A46 Newark Bypass

Statement of Common Ground with Think Again A46 Winthorpe Action Group

**Statement Of Common Ground with
Think Again A46 Winthorpe Action Group - TA**

Regulation Number:	8(1)(e)
Planning Inspectorate Scheme Reference	TR010065
Application Document Reference	7.31
Author:	A46 Newark Bypass Project Team, National Highways

**Figure 2.4 Locations of Temporary Works Areas Required During
Construction**

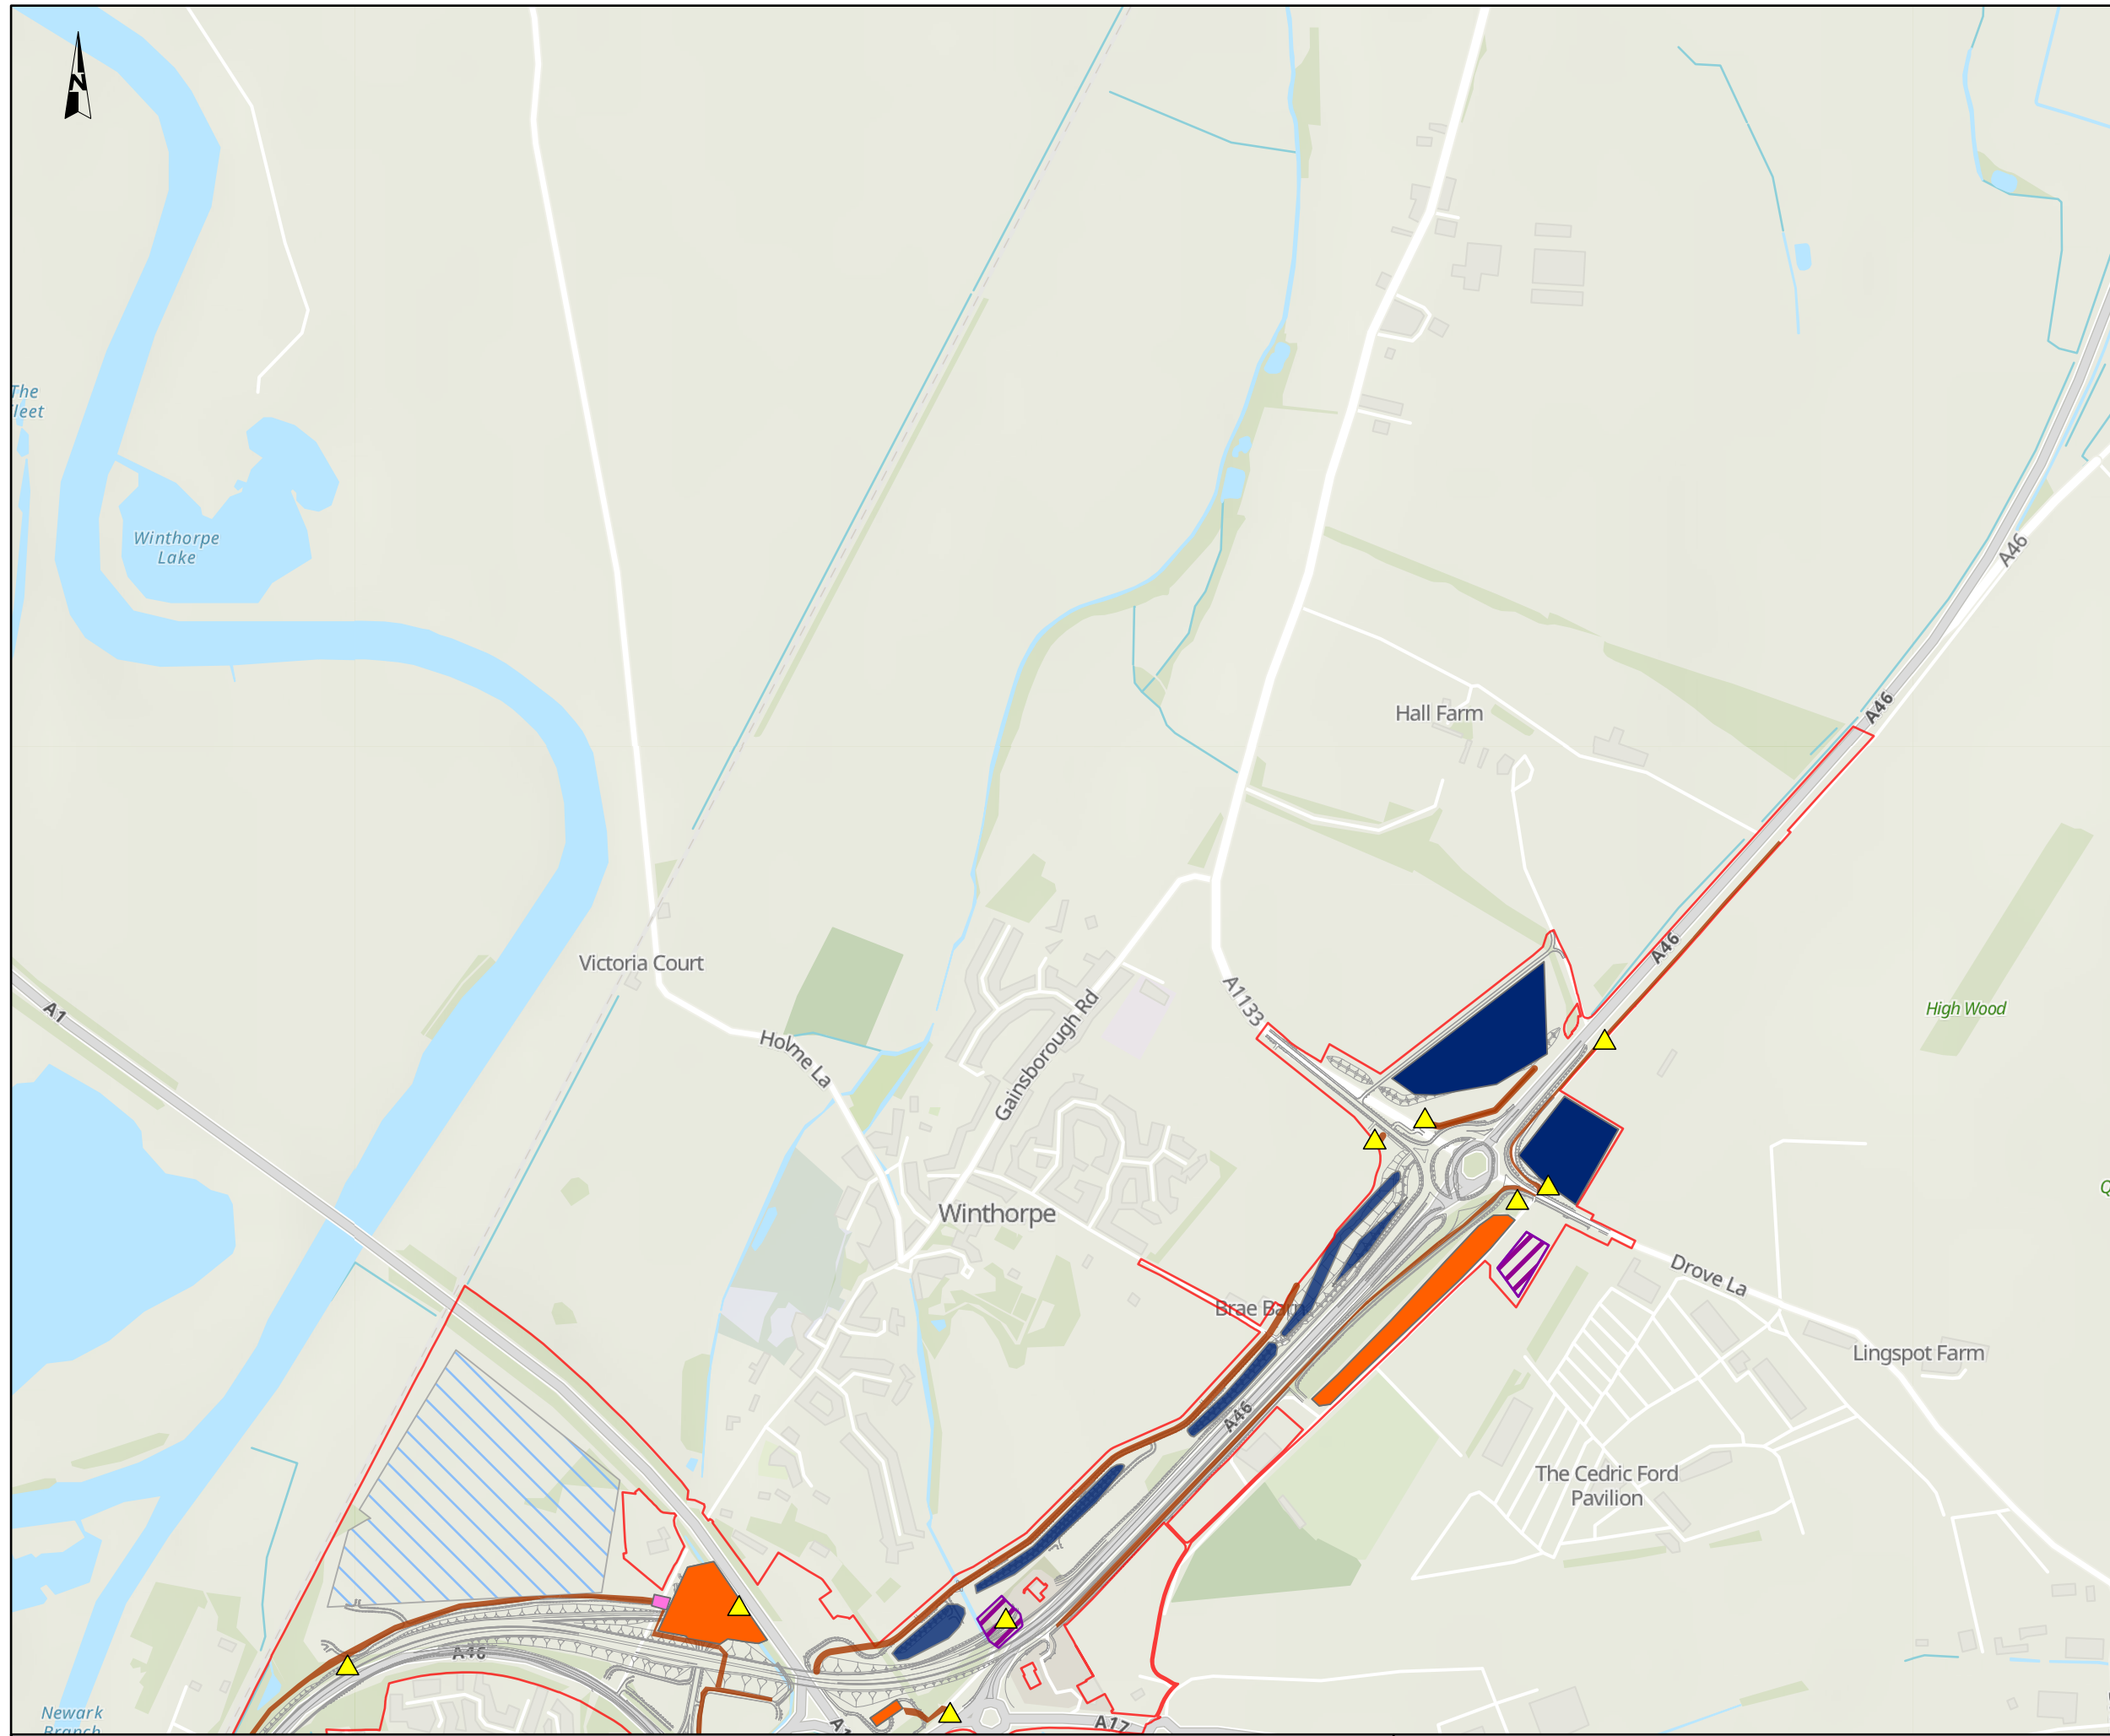
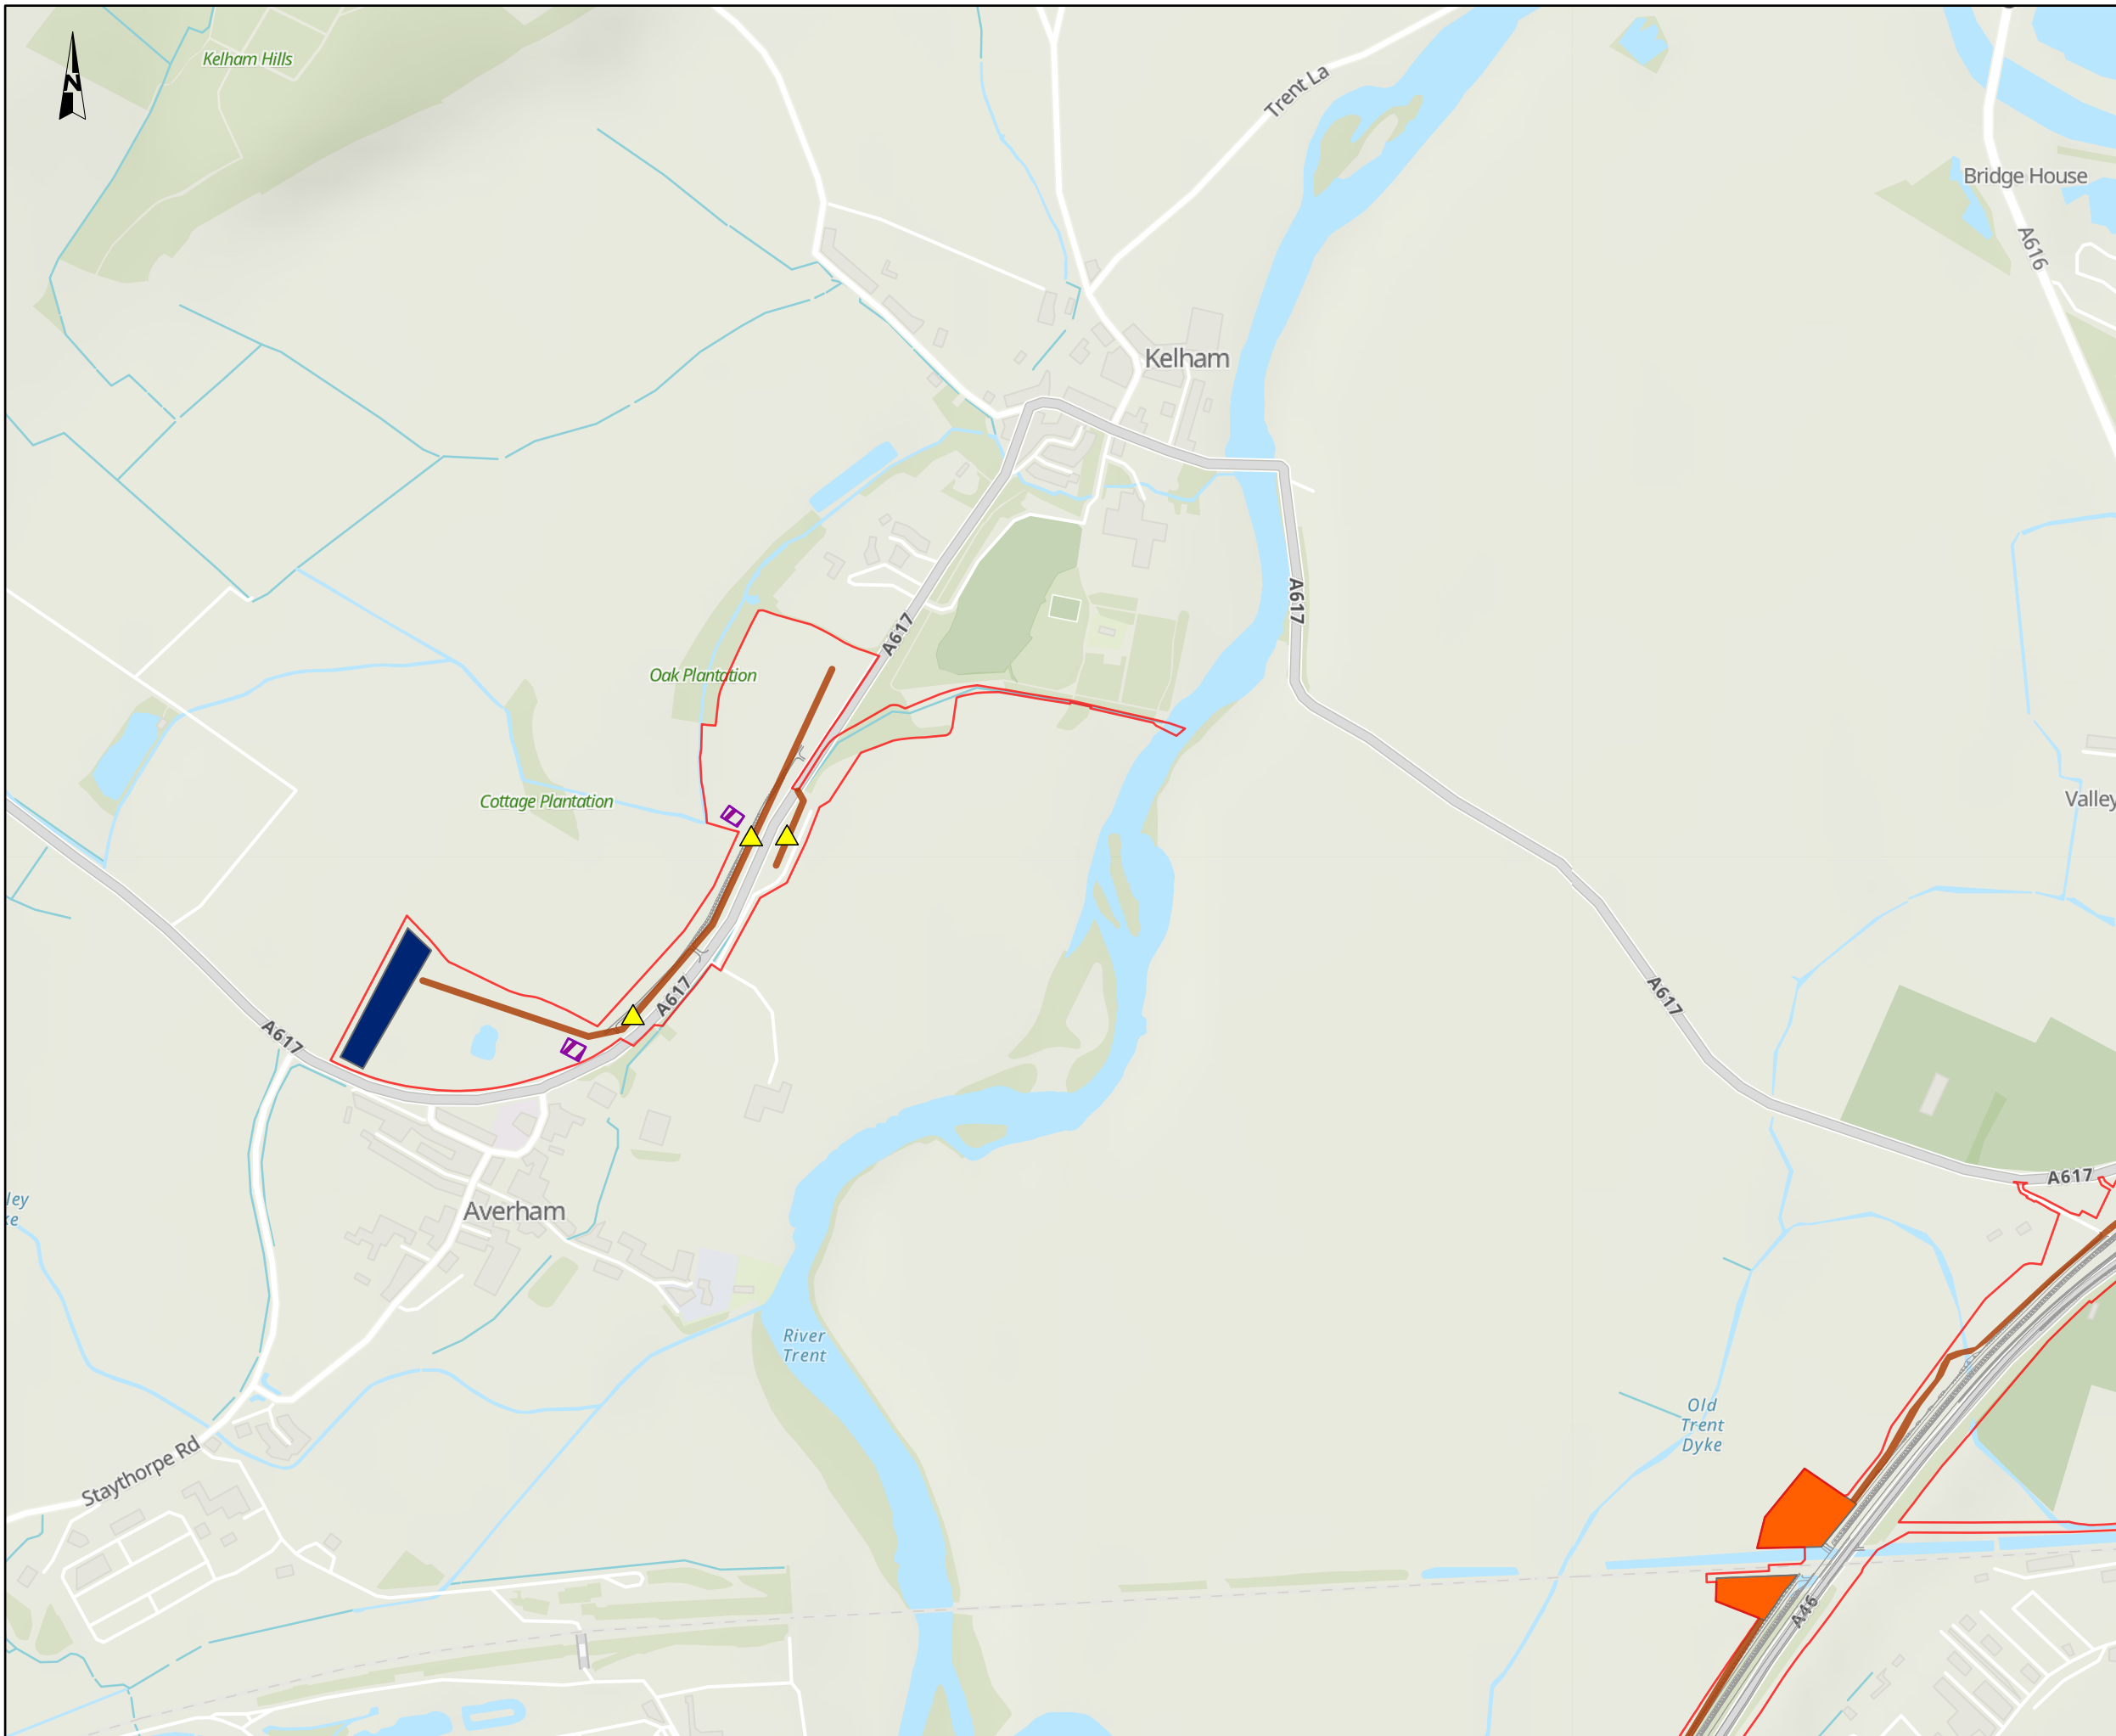
20.	Construction Compounds	<p>Figure 2.4 Locations of Temporary Works Areas Required During Construction of the Environmental Statement Figures [AS-027]</p> <p>Table 2-6 in Chapter 2 The Scheme of the Environmental Statement [APP-046]</p>	What construction compounds and works access facilities will be located in the Winthorpe area?	The location of the construction compounds and works access areas within the Winthorpe area are detailed on Figure 2.4 Locations of Temporary Works Areas Required During Construction of the Environmental Statement Figures [AS-027] and in Table 2-6 in Chapter 2 The Scheme of the Environmental Statement [APP-046].	Agreed	24/09/2024
